## MEMORANDUM

DATE: April 3, 2020  
TO: Gabe Sevigny, PCD-Planning  
FROM: Jeff Rice (719-520-7877), PCD-Engineering  
SUBJECT: MS-20-002 – Dwire Storage Yard Filing No. 1  
First Submittal

**LSC Responses (7-11-2020): See below.**

GRADING AND EROSION CONTROL PLAN

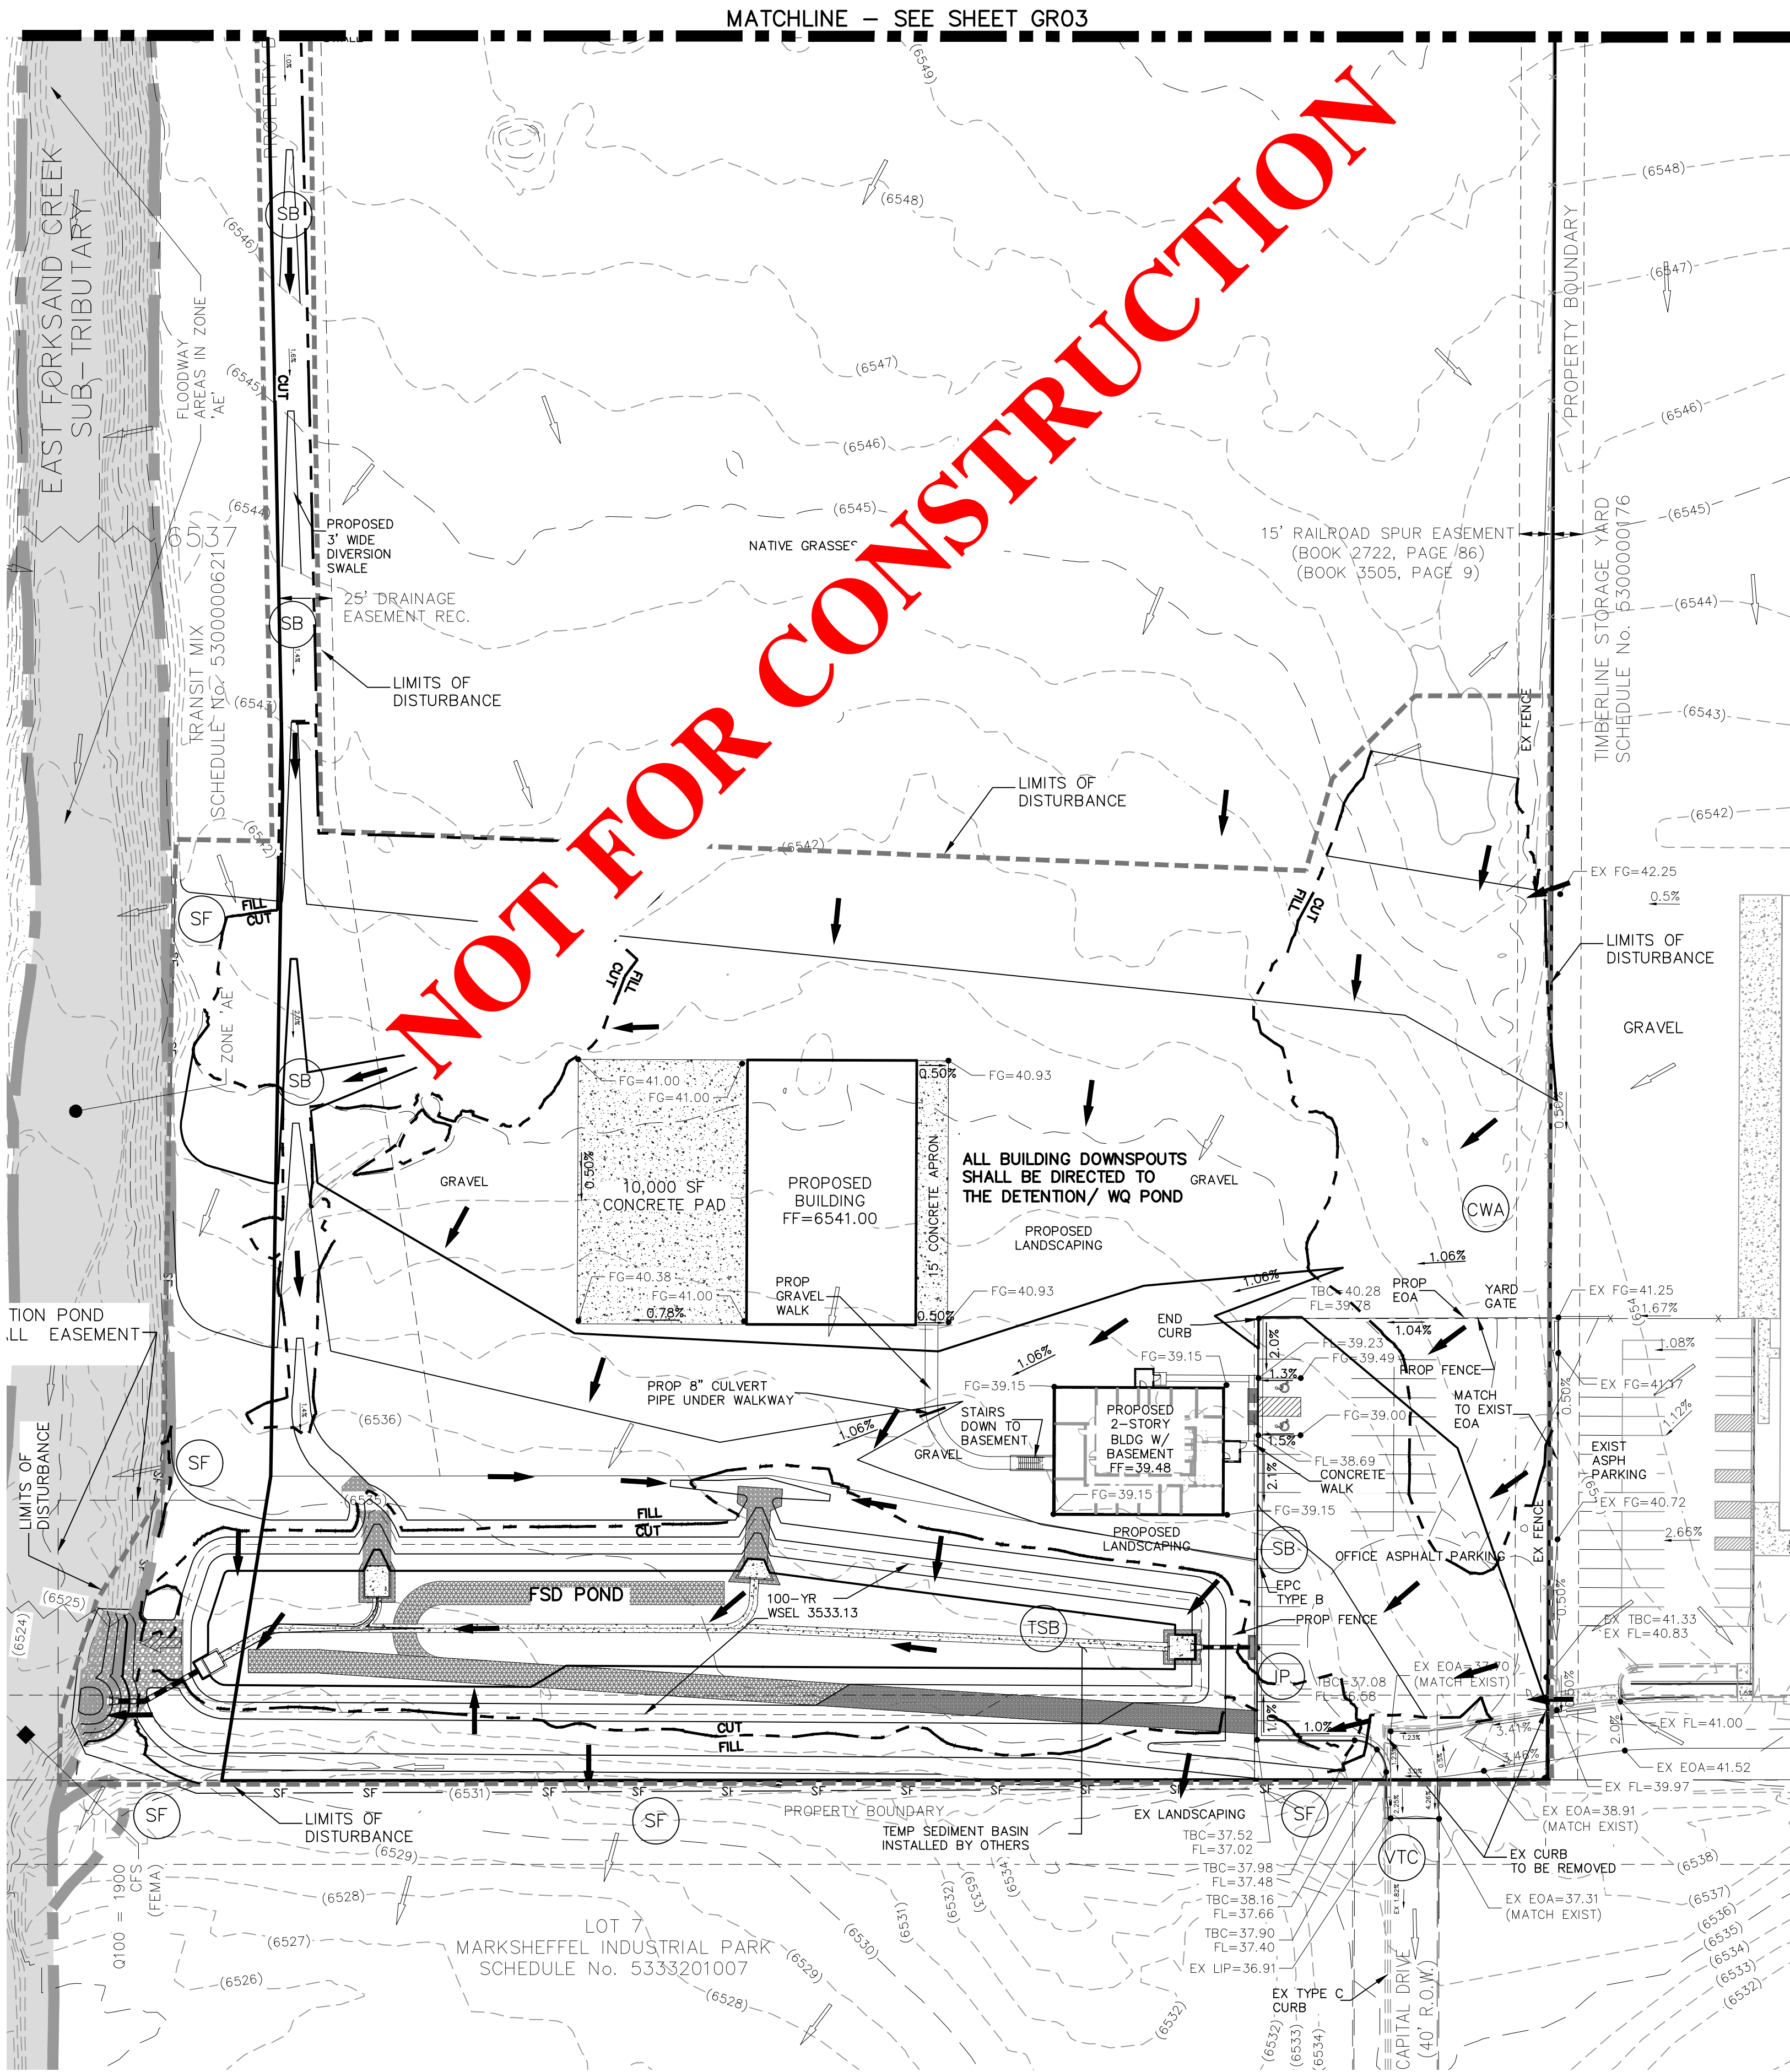
4. Show and label the offsite easement to the west for detention pond construction and outfall.
5. Show and label all existing and proposed easements including the 10-foot drainage easement on the property to the south.

6. Note: the silt fence (or other BMPs as revised) shown on the property to the south requires permission from that owner to install. Some type of channel erosion and sediment control is (straw checks/sediment control logs/etc.) should be provided in the revised flowline. Provide documentation from the adjacent property owner that the change in drainage pattern (runoff from Dwire property, being pushed from the existing swale onto their property) is acceptable to them. Label the side slope and flowline grades of this adjusted swale. Ensure that no utilities are impacted.

7. The offsite easement to the west needs to be provided (signed) prior to grading, or the plans revised as necessary to avoid offsite grading.
8. Revise the SWMP as applicable for changes to the extent and type of improvements discussed in the General, CD, and FDR comments.
